27 January 2017

Our Ref: KFOR 16/76 Pt 2

Kings Forest Major Project Approval No. MP08-0194 (MOD 3)
Service Station & Food and Drink Premises – Precinct 1

FLOOR PLAN AREA SUMMARY

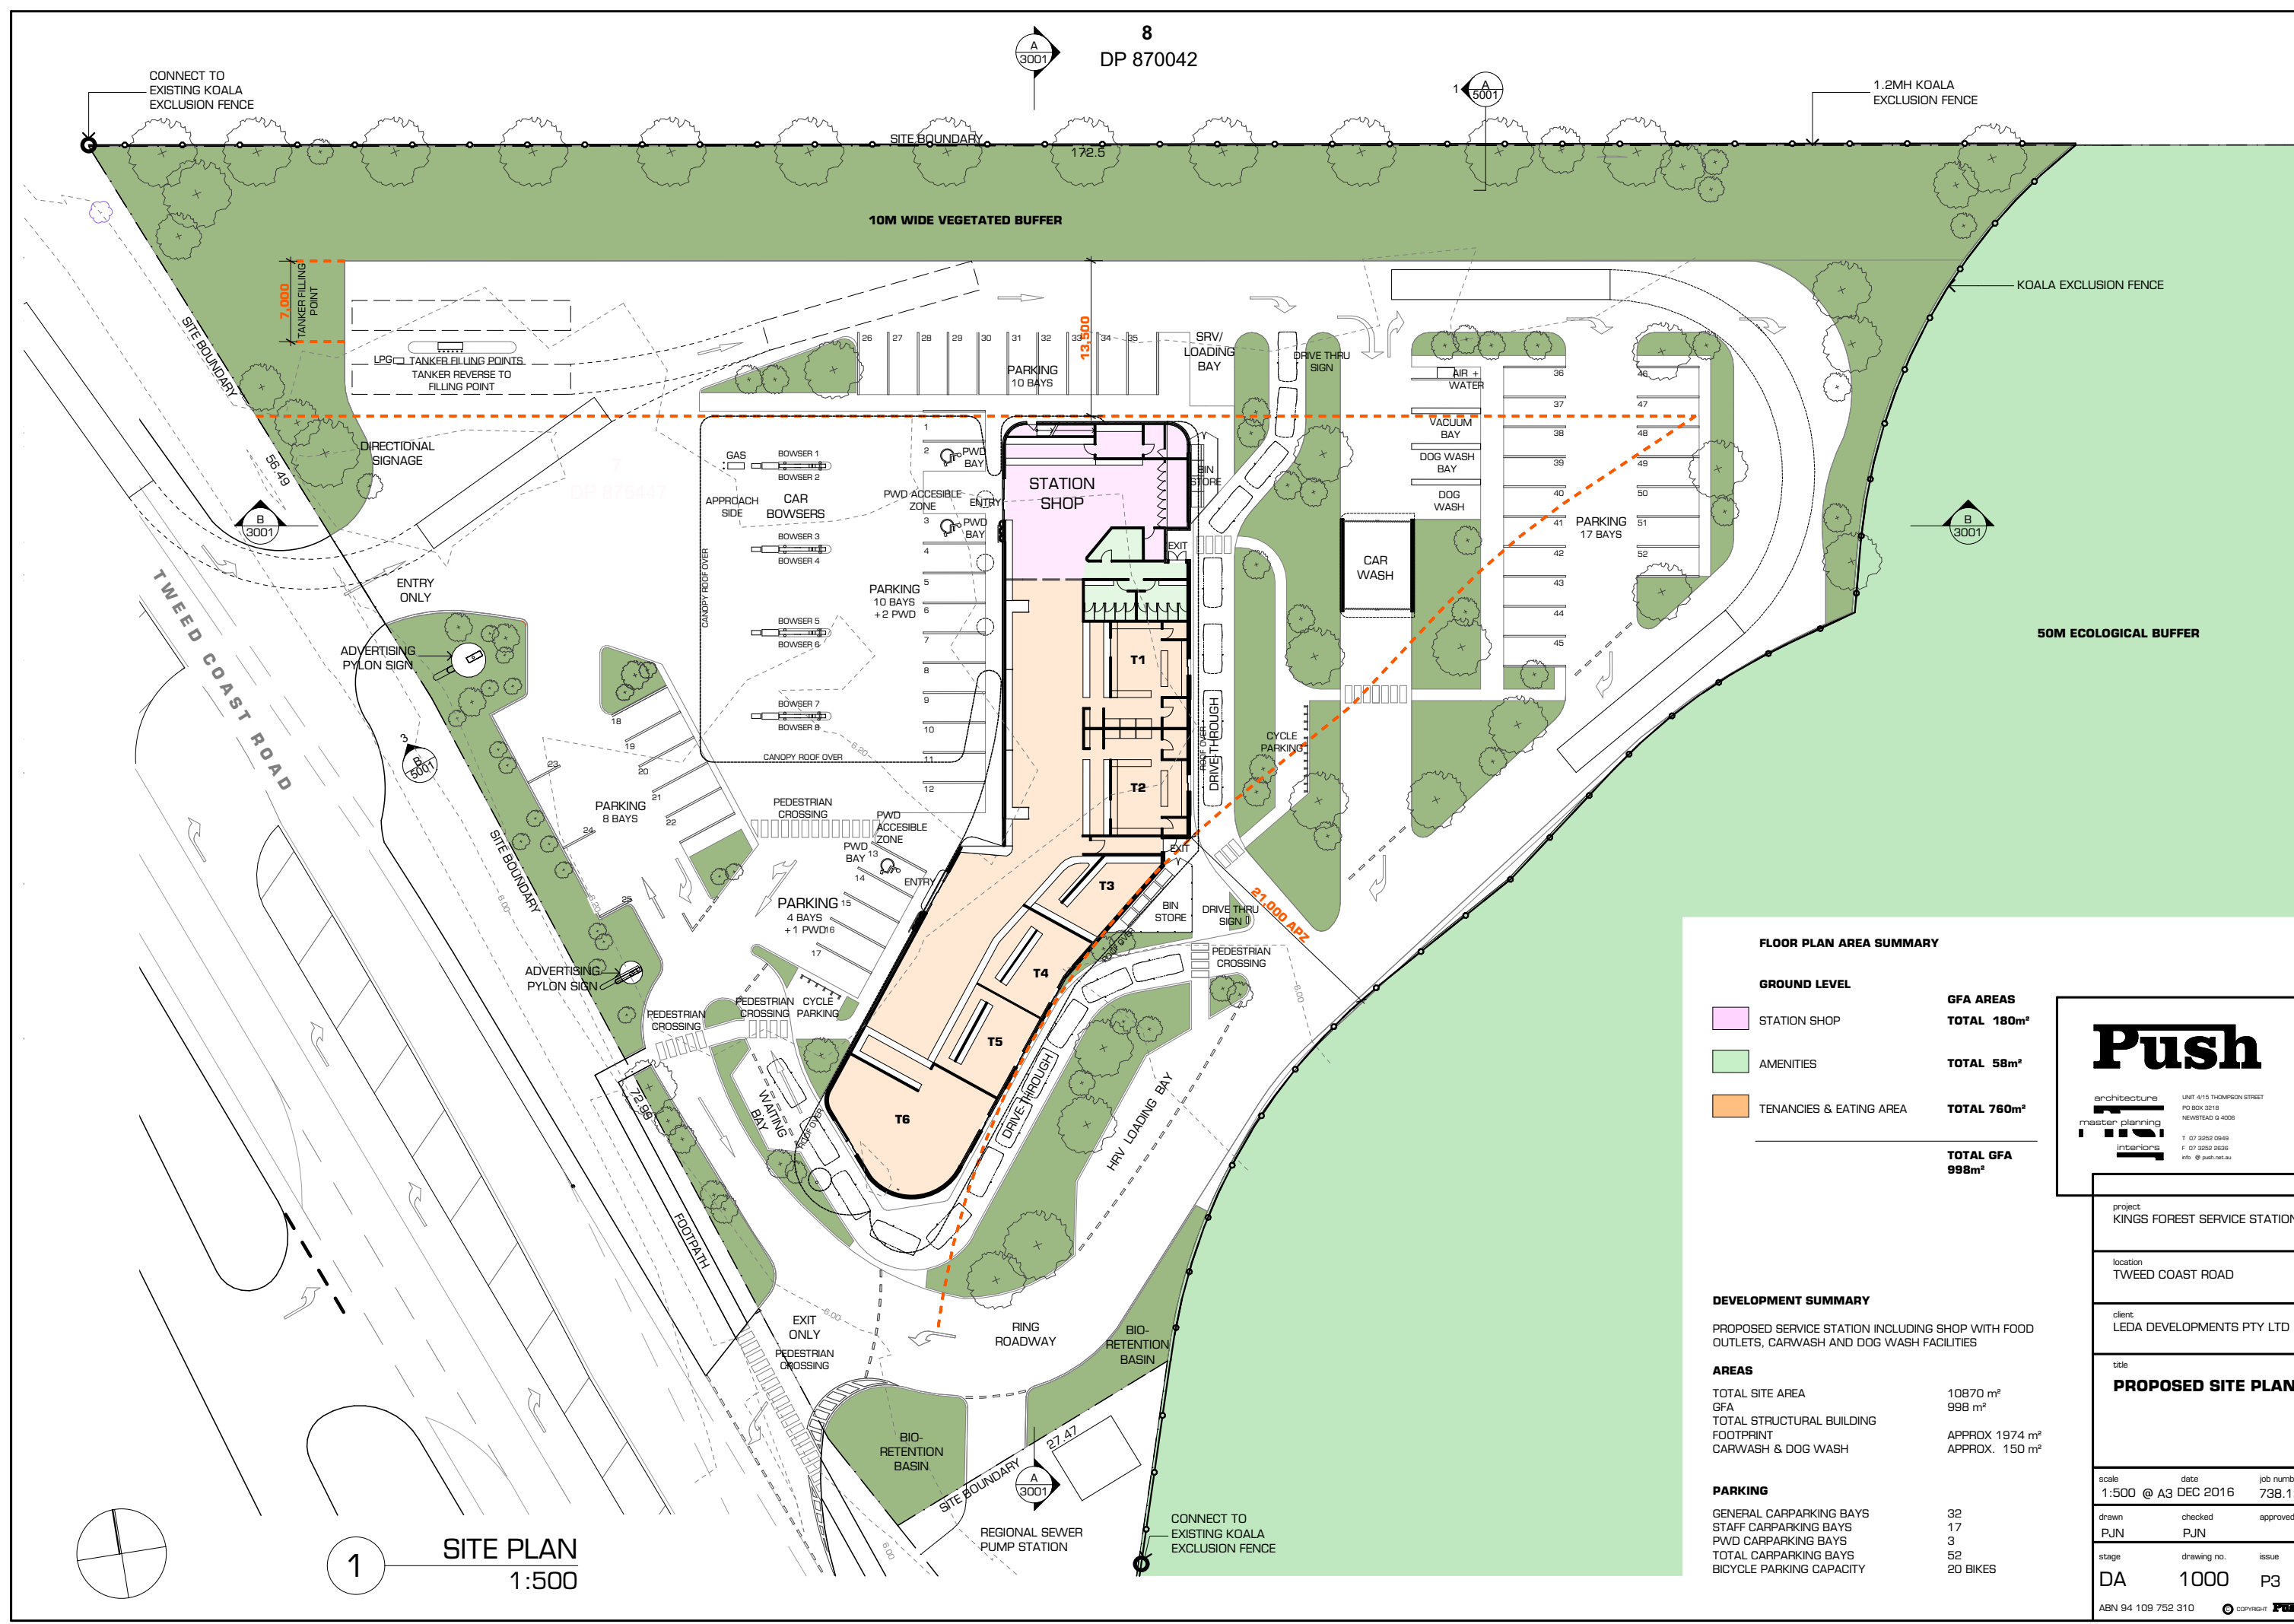
- Building location as per original submission (21.0m East setback maintained)
- Increased North buffer (10m wide vegetated)
- Building extent to North reduced (station shop reconfigured) to achieve 13.5m setback to vegetated buffer

- Distance between car bowzers and station shop car parking increased (from 7m to 8m)
- Bowzers and roof over shifted South to achieve 13.5m setback to roof line

- Truck bowzers deleted
- Tanker filling point relocated (Distance of 7m from vegetated buffer to tanker filling point)
- Revised traffic movements (car and AV swept path)

- Revised car parking (from total 73 carparks to total 52 carparks)
- Carwash, dogwash, vacuum, air/water relocated to East of site (carwash building *clear of & not* within 21.0m East setback)

- Number of pylon signs reduced (from 4 to 2 signs)
Pylon signs noted on plan
- Deletion of the roof top terrace
- The internal stair to the roof terrace has been removed from the plan

- Roof Terrace floor area (sqm) has been removed from the drawing and subtracted from the total GFA area calculation
